# CITY OF ALBUQUERQUE

July 29, 2009

**Re: Scott & Kienzle Law Office, 1101 Las Lomas Dr. NE**  
**Request for Permanent Certificate of Occupancy (C.O.)**  
**Approved Engineer's Stamp dated 04/29/2008 (J-15/D092)**  
**Certification dated 075/06/2009**

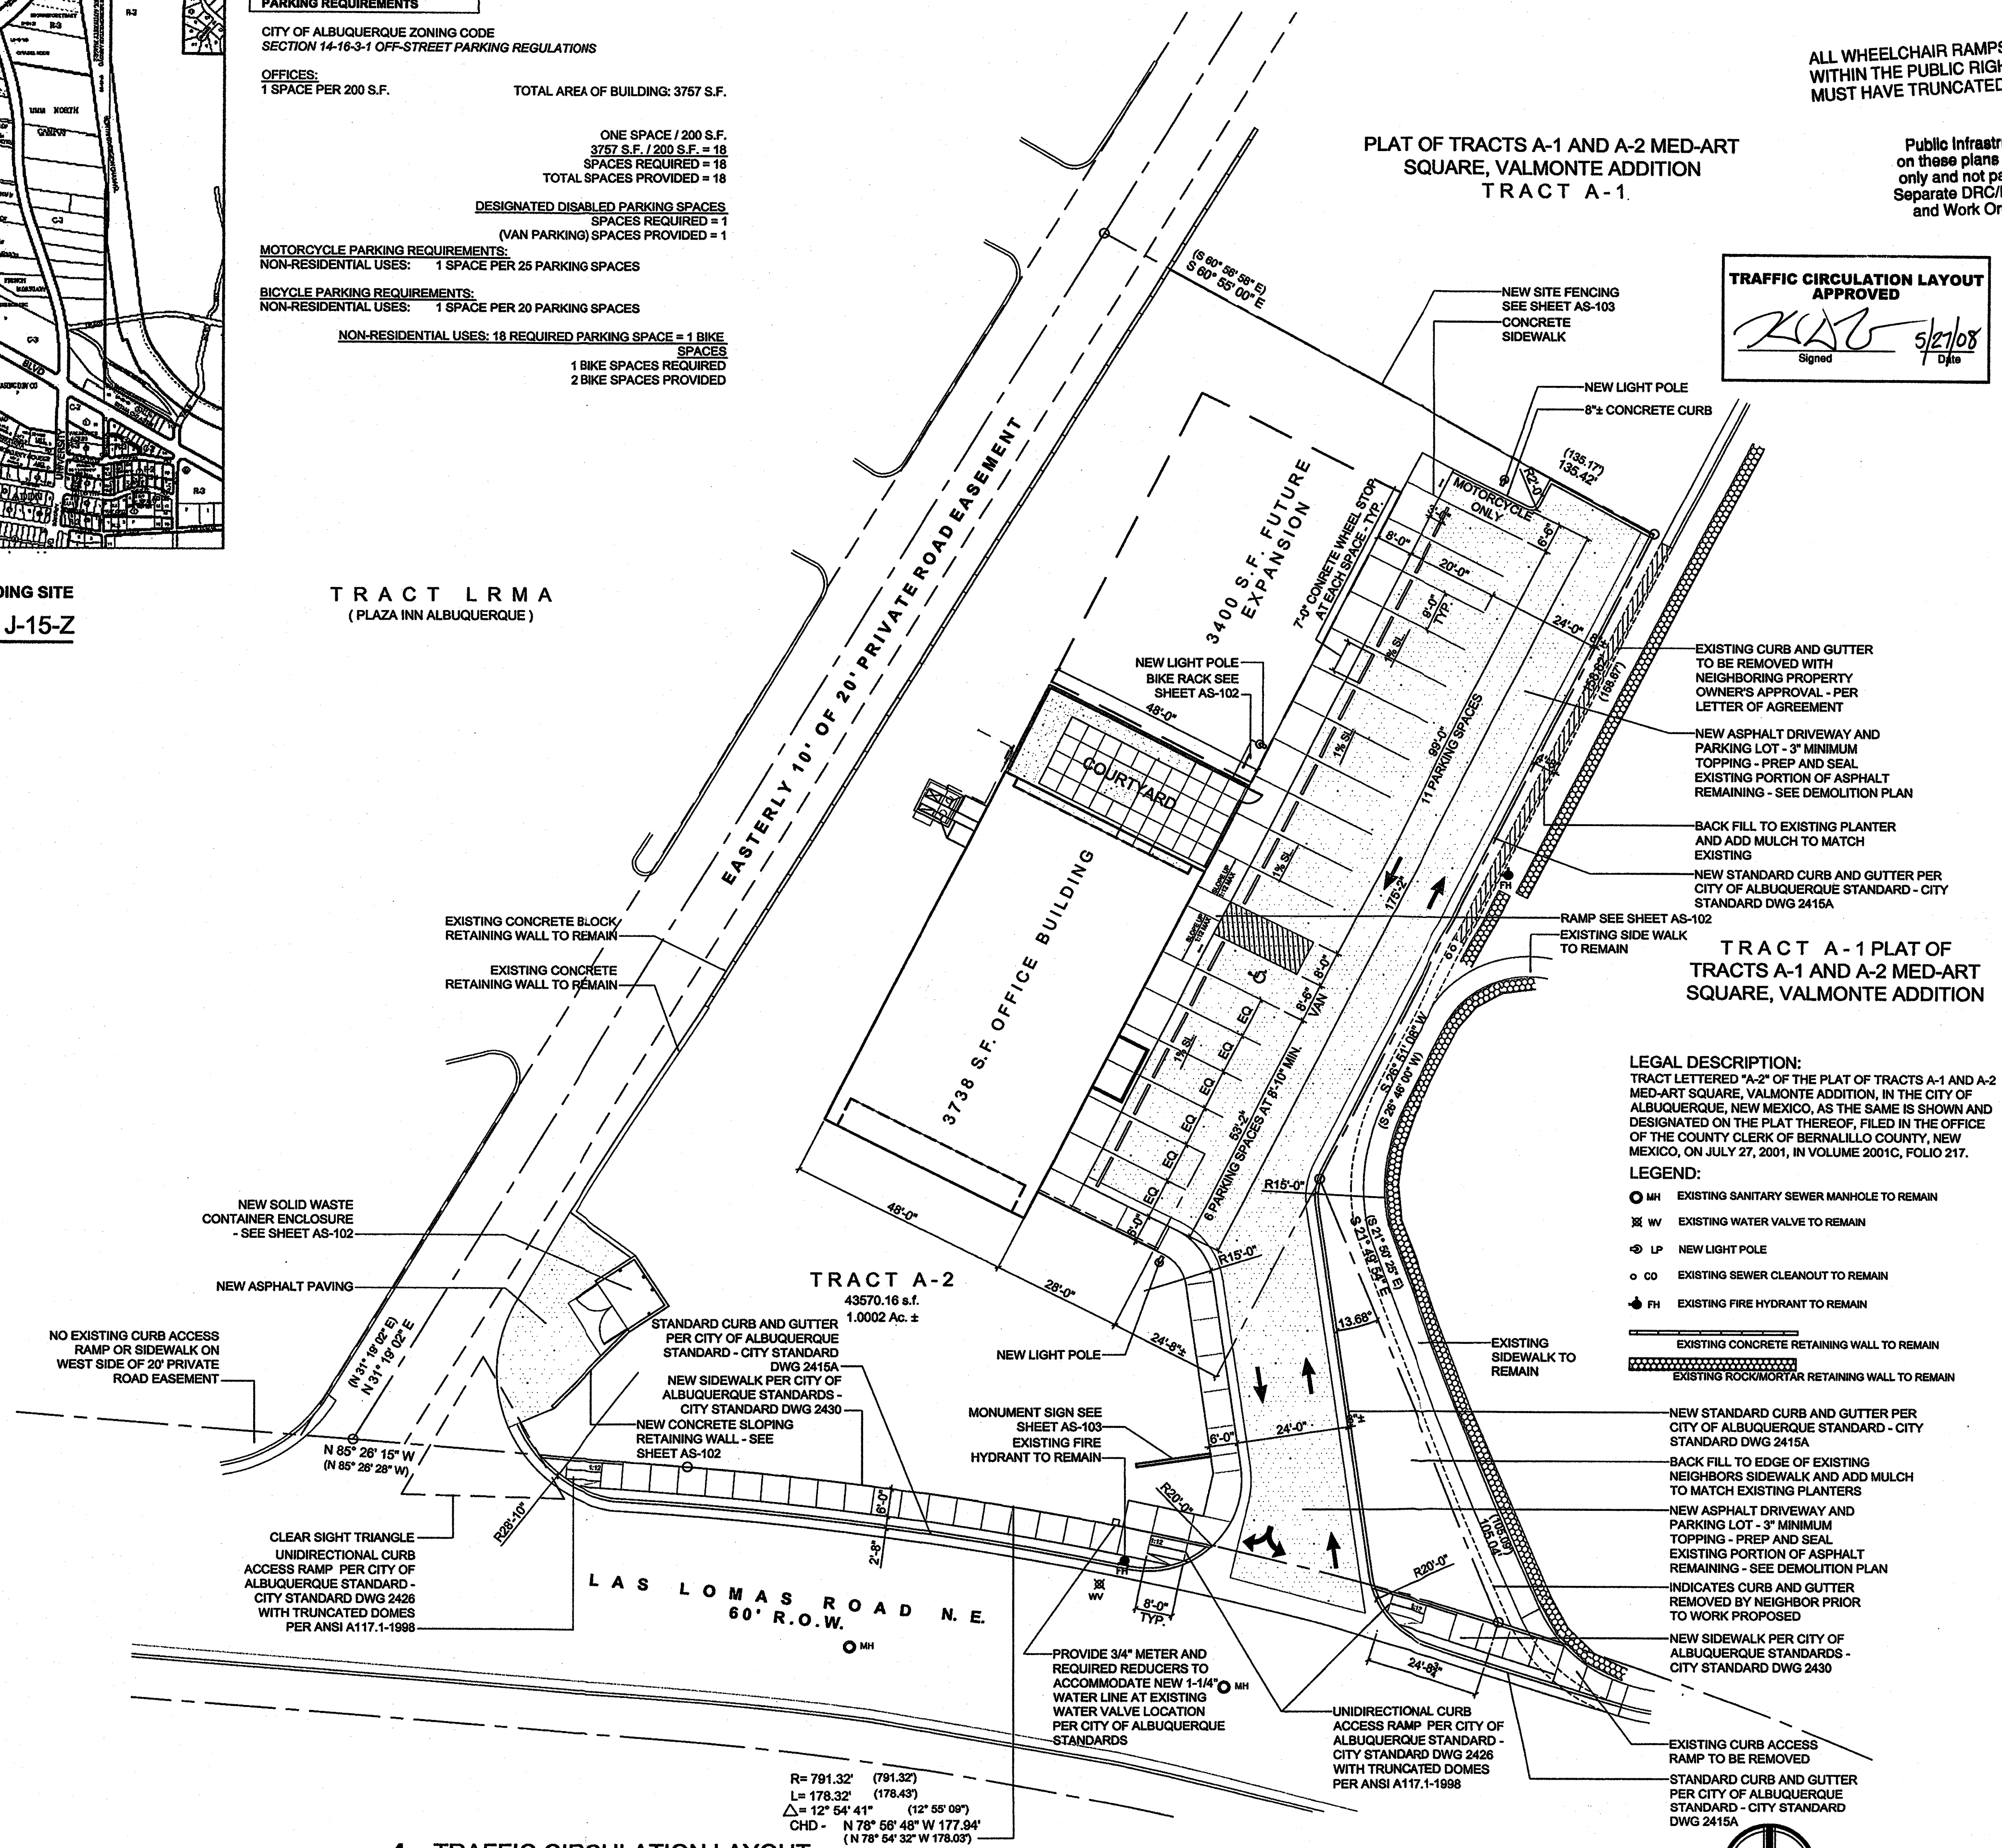
1. A 6-foot wide pedestrian path must be maintained. Does the proposed gate interfere with this path?
2. Is there currently a ramp west of the 20' private road at Los Lomas Road?
3. A portion of the proposed work appears to be located on the adjacent lot. The cross lot access easement has been vacated; therefore, this cannot be built as shown.

- ✓ 1. Remove all non-traffic related items from the Traffic Circulation Layout (TCL) submittal.
- ✓ 2. List radii for all curves shown.
- ✓ 3. Please show a vicinity map.

- ✓ 8. A 6 foot wide pedestrian path must be maintained. Does the proposed gate interfere with this path?
- ✓ 9. The handicapped spaces must include an 8-foot wide van access aisle; all other aisles should be 5 feet in width. This access aisle will need to be to the right of the parking stall.

- ✓ 10. Please place the proposed sidewalk at the property line, not the back of curb. The pedestrian path and sidewalk along Las Lomas Road will need to be six feet (6') in width.

- ✓ 11. Please ensure all ramps are ADA compliant. All proposed ramps within the City Right-of-Way are required to have truncated domes.
- ✓ 12. Is there currently a ramp west of the 20' private road at Los Lomas Road?

- ✓ 13. Provide a detail of the wheelchair ramps located at the driveway, or refer to the appropriate city standard.
- ✓ 14. In addition, a passenger vehicle must be able to turn around within the drive before a gate can be placed. Please provide a detail demonstrating how this will occur.

1. A proposed gate is shown at the northeast corner of the site. Your detail sheet defines this as a "traffic gate." You no longer have cross lot access, and therefore cannot have a connection here.
2. Provide written permission from the adjacent property owner to perform the proposed work on their property. An exhibit, detailing the area impacted, must be included.
